Please find the response to the public consultation with regards the North Arms Public House 19/01148/F

Planning Application 19/01148/F

**Drawing**  
Proposed first and second floor plans

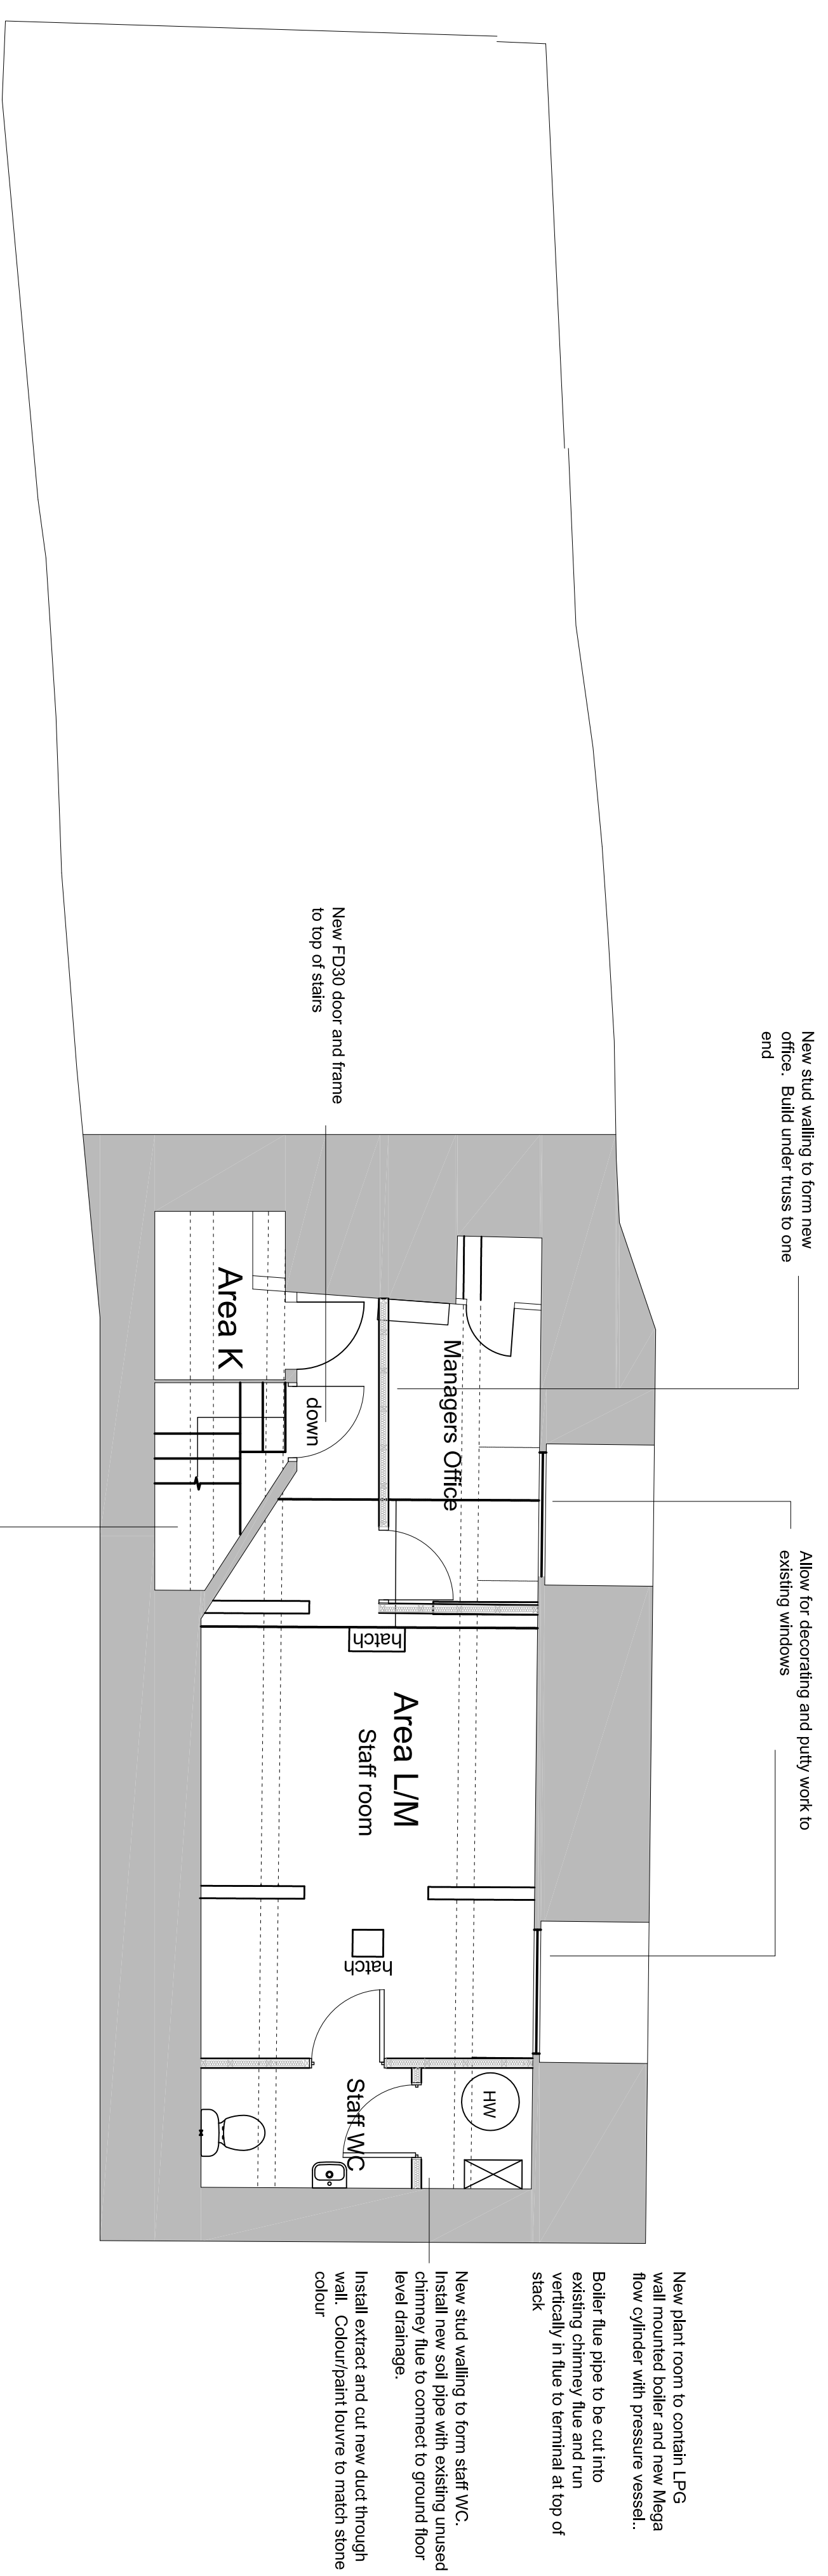
The proposal introduces a significant impact on residents by relocating a commercial kitchen from its current location (discharging over the North Arms Public Car Park), with an option to relocate the commercial kitchen to within meters of neighbouring properties. Lack of detail in the planning application raises several concerns.

- i) The proposal indicates that the commercial kitchen will have low level extraction (first floor) and the discharge of cooking fumes, heat and steam will directly affect surrounding properties that have windows at the same height. We therefore note that it is foreseeable that both noise and odour will be a concern or constitute a nuisance when applying Local Authority Guidance for extraction systems. We understand that a high specification filtration system maybe able to offer an engineered solution to any potential odour issue. The noise issue will need very careful design and any impact will need careful consideration.

We have proposed that one option could be for the application to consider extracting the kitchen with the use of the existing redundant chimney, this will alleviate the low-level discharge issue and would assist with odour control. We were unsure and a little concerned that the Environmental Health professional assessment of these were stated as no comment response to all the material matters there were internally consulted on as part of this application. It was not clear if the British Standard for Extraction had been used as guidance for this professional assessment. It is not clear if there are no adverse comments, or the proposal is considered acceptable, or just no comments.

**Drawing**  
**Proposed Elevations**

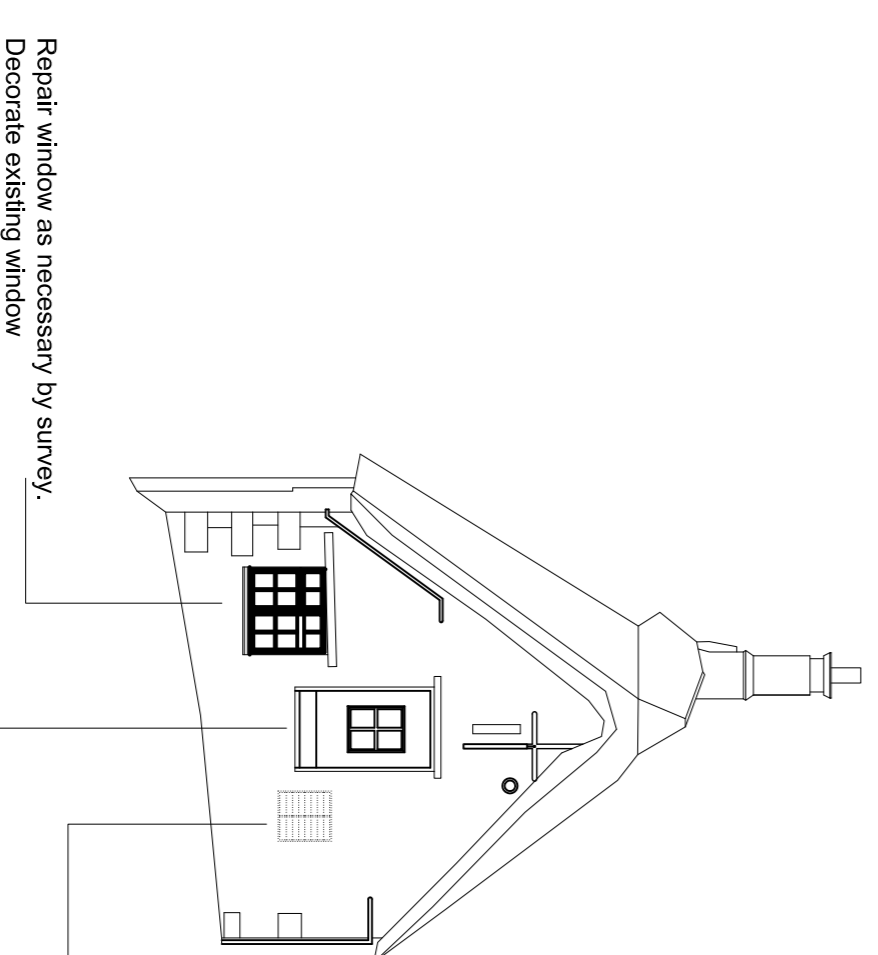
It appears that the proposal suggests the re-introduction of a historically blocked up doorway on the Mills lane elevation, we note that there is a commitment to keeping

the door and altering it so both doors open outwards as part of the protected means of escape. There needs to be a balance in that if any customers or staff were to use this door it exits directly onto Mills Lane and in an emergency will see persons escaping in an emergency standing in the road with little or no safe place. It maybe possible to protect customers and staff alike with a planning condition that this exit is used in emergency only.
